File no. SF17/39348
DOC No: DOC17/430372

WestConnex M4-M5 Link (SSI 7485) – Comments on Environmental Impact Assessment

16 October 2017

Figure 20-15 Listed and potential heritage items directly impacted at Rozelle, Lilyfield and Annandale

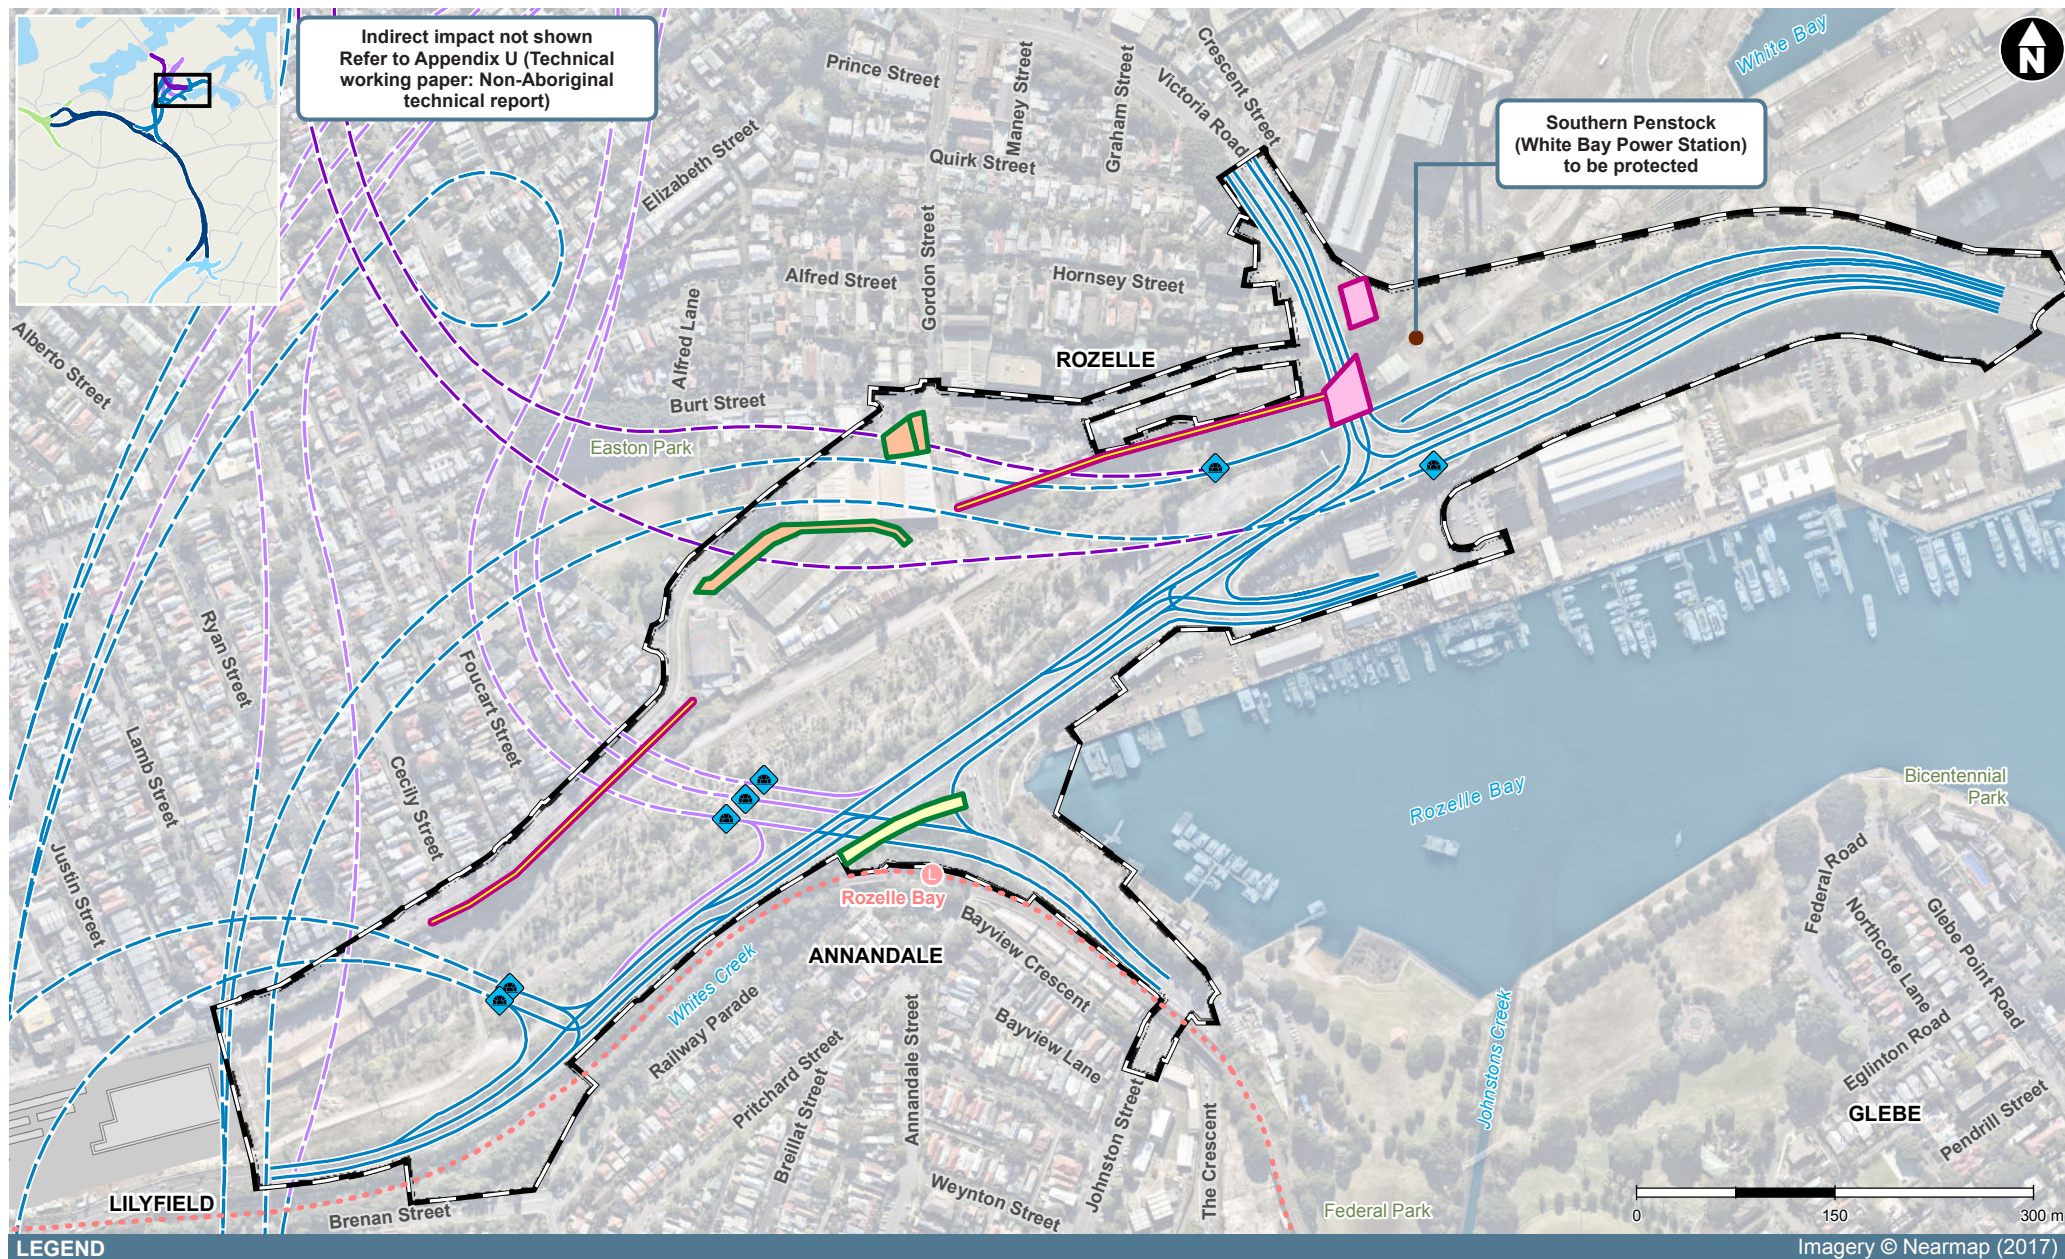
The works also involve the demolition of three items listed as being of local significance on the SREP 26 Heritage Register along Lilyfield Rd. Two of these items, late nineteenth century Cadden Le Messurier, and 1878 Former Hotel are on the edge of the of the project footprint. The need to demolish these buildings is unclear as they are some distance from the construction zone. It is therefore recommended that the project footprint is realigned to exclude these properties from the works area.

- The demolition of Cadden Le Messurier and Former Hotel at Lilyfield is not supported. The construction footprint must be modified to exclude the properties Cadden Le Messurier, 84 Lilyfield Road and Former Hotel, 78 Lilyfield Road from the construction zone.

Figure 20-16 Listed and potential heritage items directly impacted at Victoria Road (east of the Iron Cove Bridge)

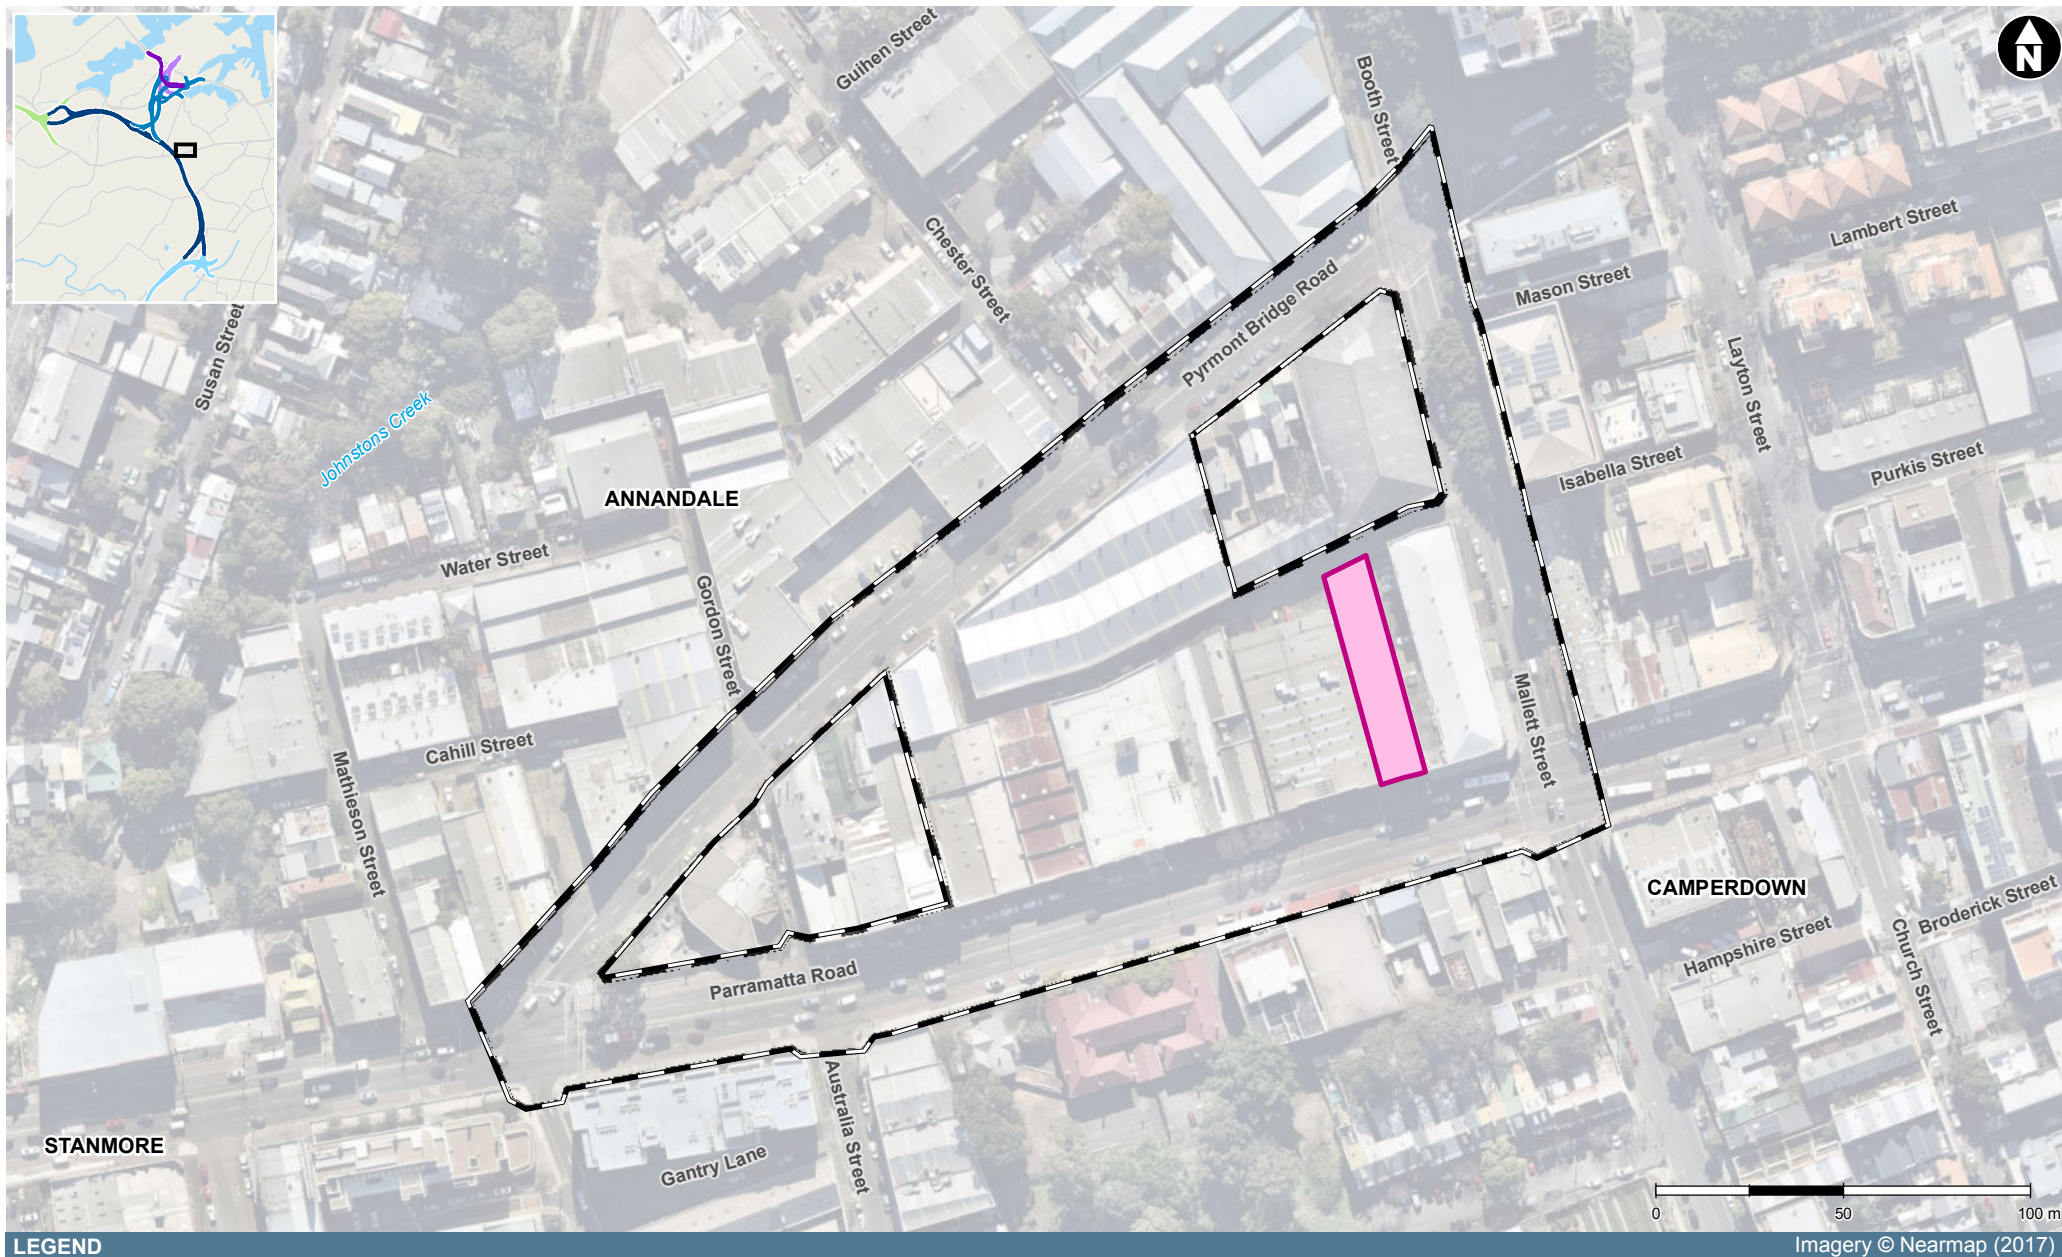
As part of works within this area, six buildings identified as being of potential local heritage significance are proposed to be demolished. Their demolition is not supported, as it would

diminish the character of the area. However, if demolition is approved, historic fabric and features must be salvaged for distribution back to the former landowners and the local community.

- Properties adjacent to, or in the vicinity of items proposed to be demolished along Victoria Road, must be protected during the demolition works.
- The design and placement of the proposed ventilation element in the widened Victoria Road carriageway must give consideration to the surrounding character and setting of the area, including to the adjacent Iron Cove Conservation area. Opportunities to reduce bulk and scale must be explored by the proponent.

Figure 5-45 Rozelle West motorway operations complex (MOC2)

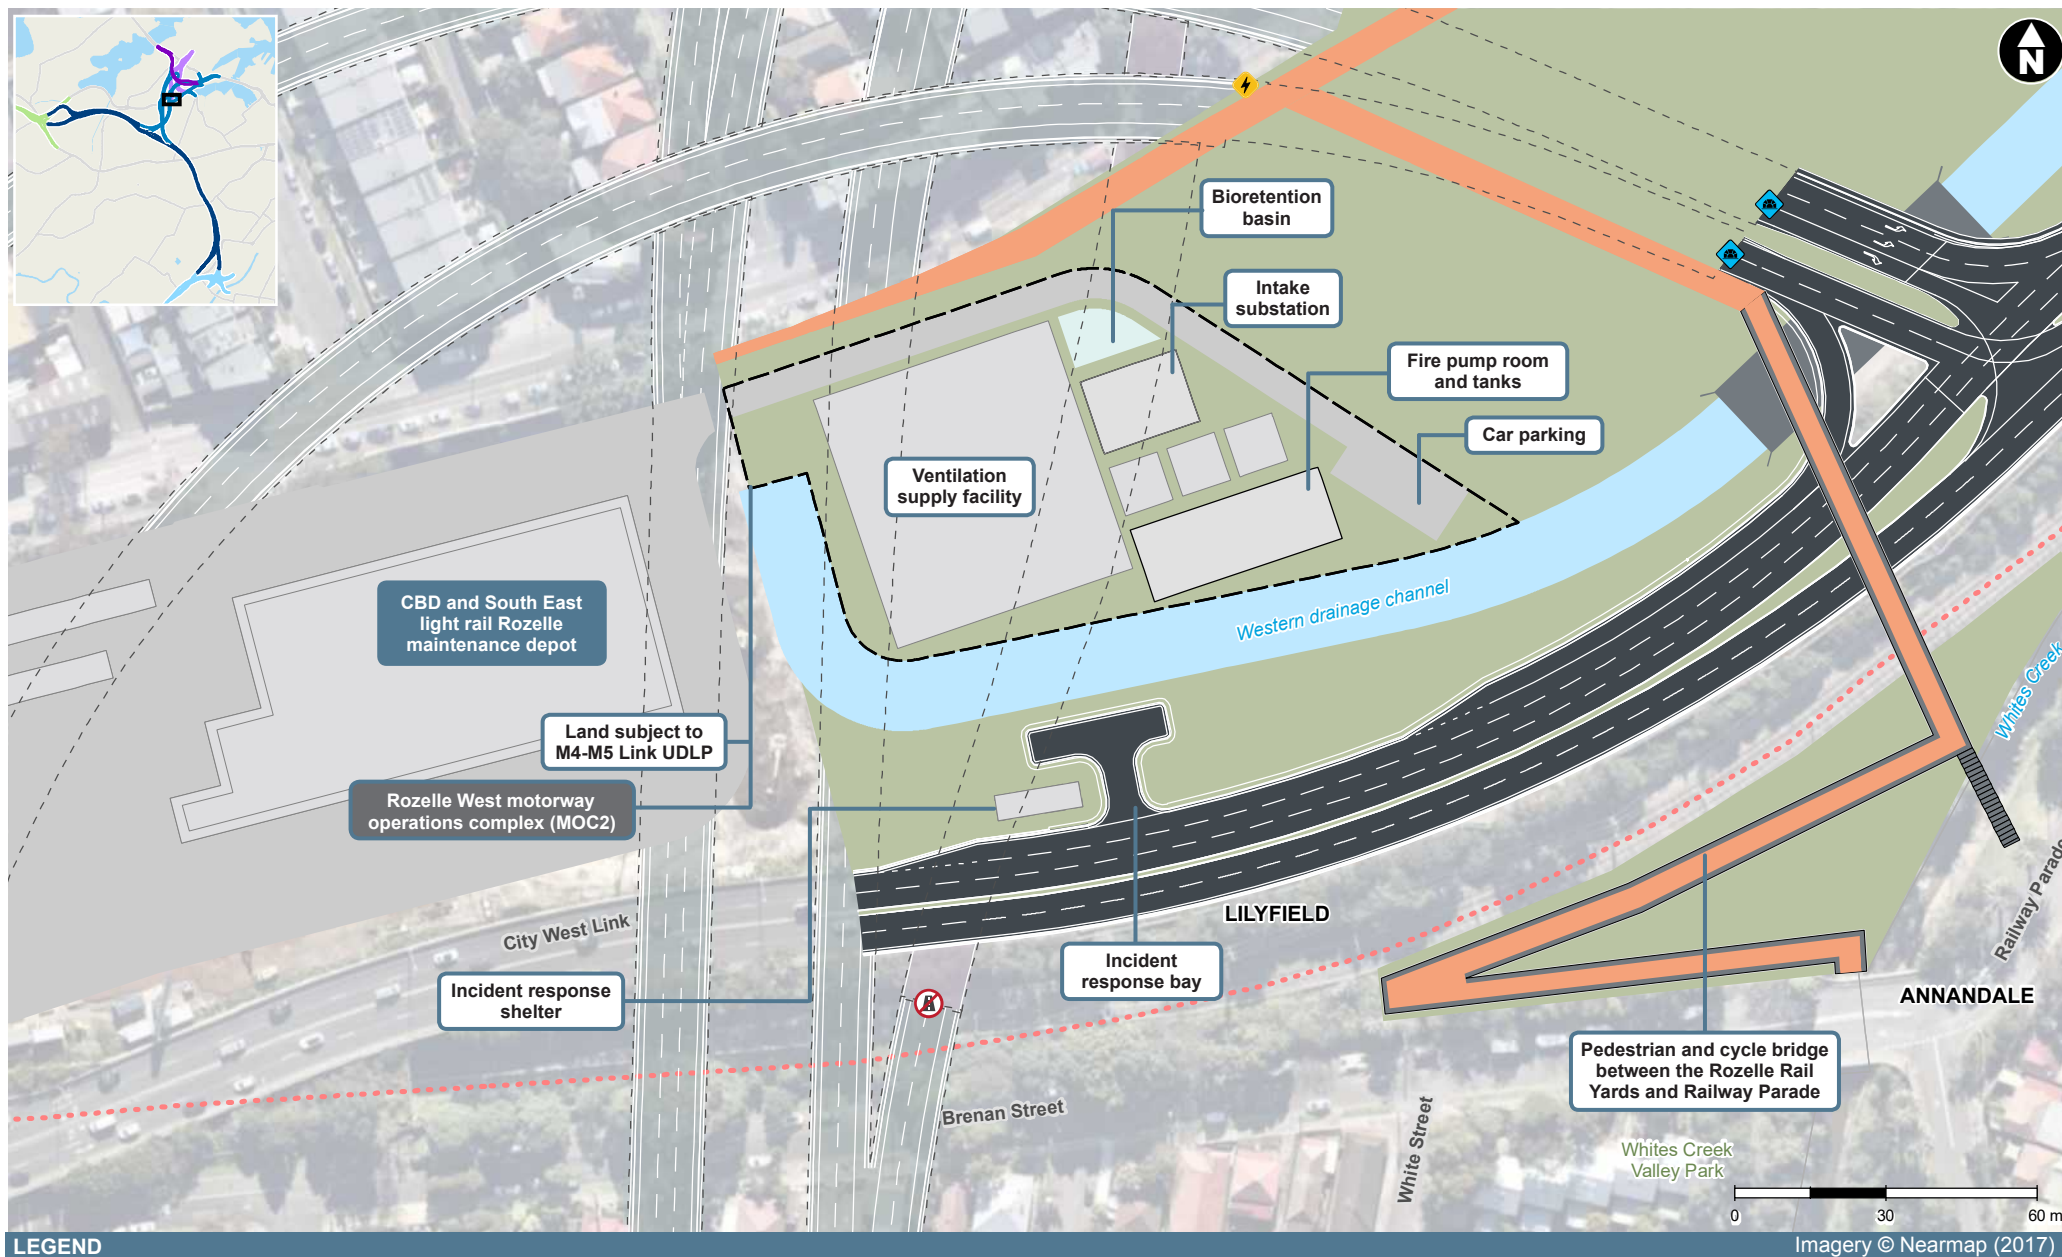
There may also be visual impacts to Charles Street Underbridge with the construction of the Motorway Operations Complex (MOC). The MOC should be positioned on the site to ensure views and vistas to the Charles Street Underbridge are not obscured. Further, monitoring must be undertaken during demolition and tunnelling to ensure the bridge is not structurally impacted.

- MOC1 must be positioned on the Darley Street site with consideration of views and vistas to the Charles Street Underbridge with the express aim to creating a visual separation between the new structures and the heritage item.

Figure 5-46 Rozelle East motorway operations complex (MOC3)

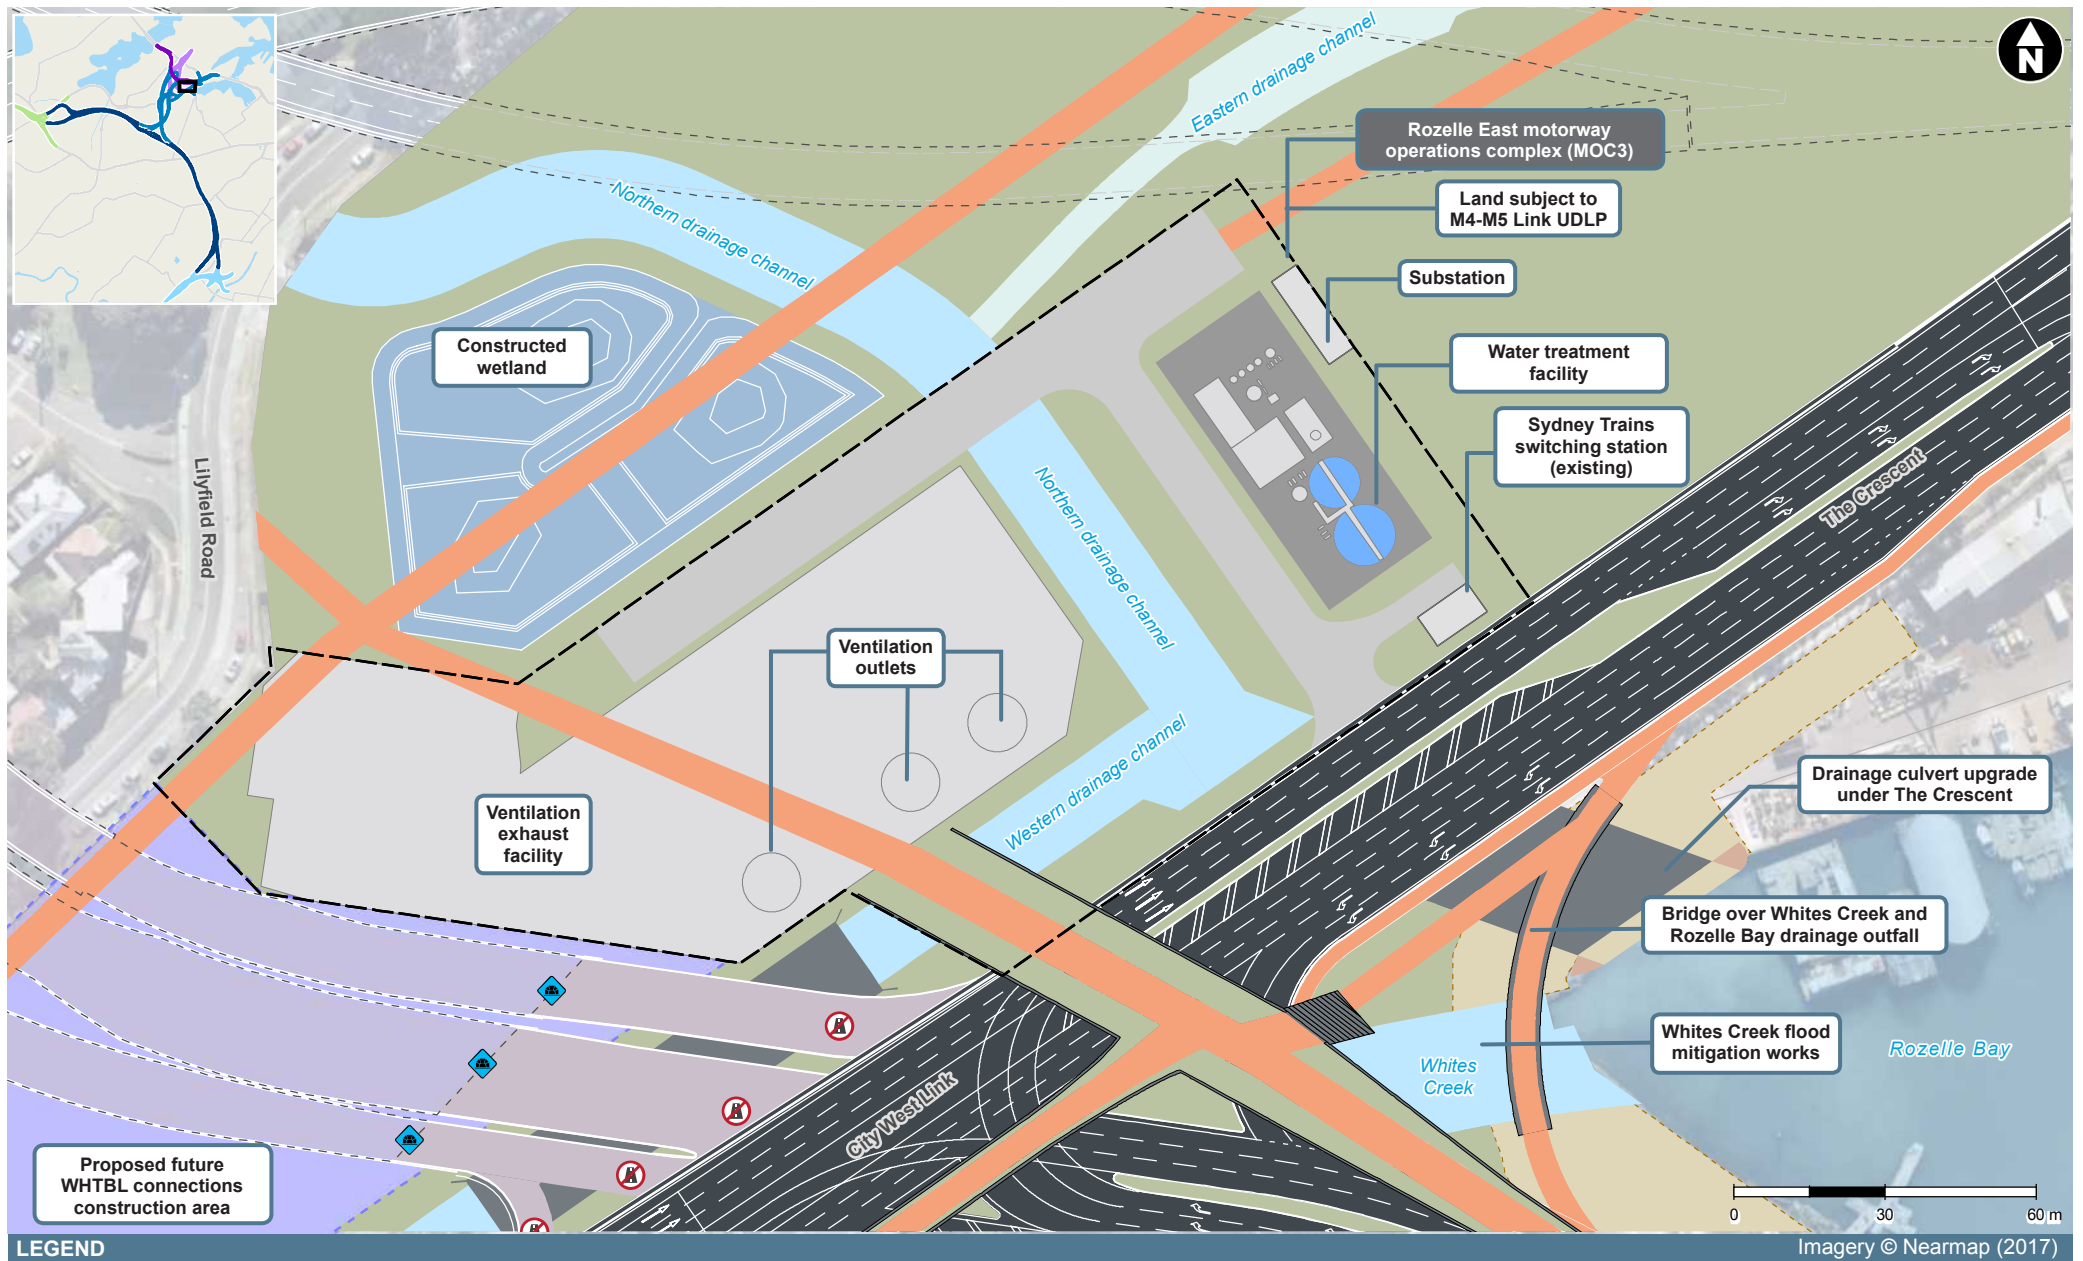
Works also include the permanent construction of two Motorway Operations Complexes (MOC) including the construction of 3 x 35m high ventilation stacks. It is understood the final design of these elements has not yet commenced. However, due to their proposed height and scale, they will potentially be visually intrusive. The design of these ventilation facilities must be sympathetic to the surrounding character and setting, including the Hornsey Street, Easton Park and Brenan Estate Conservation Areas. The design must also ensure views to the SHR listed White Bay Power Station are not impacted.

- The design of the ventilation facilities at MOC3 must give consideration to the surrounding character and setting, and ensure views to the SHR listed White Bay

Power Station are not impacted. Opportunities to reduce bulk and scale must be explored by the proponent.
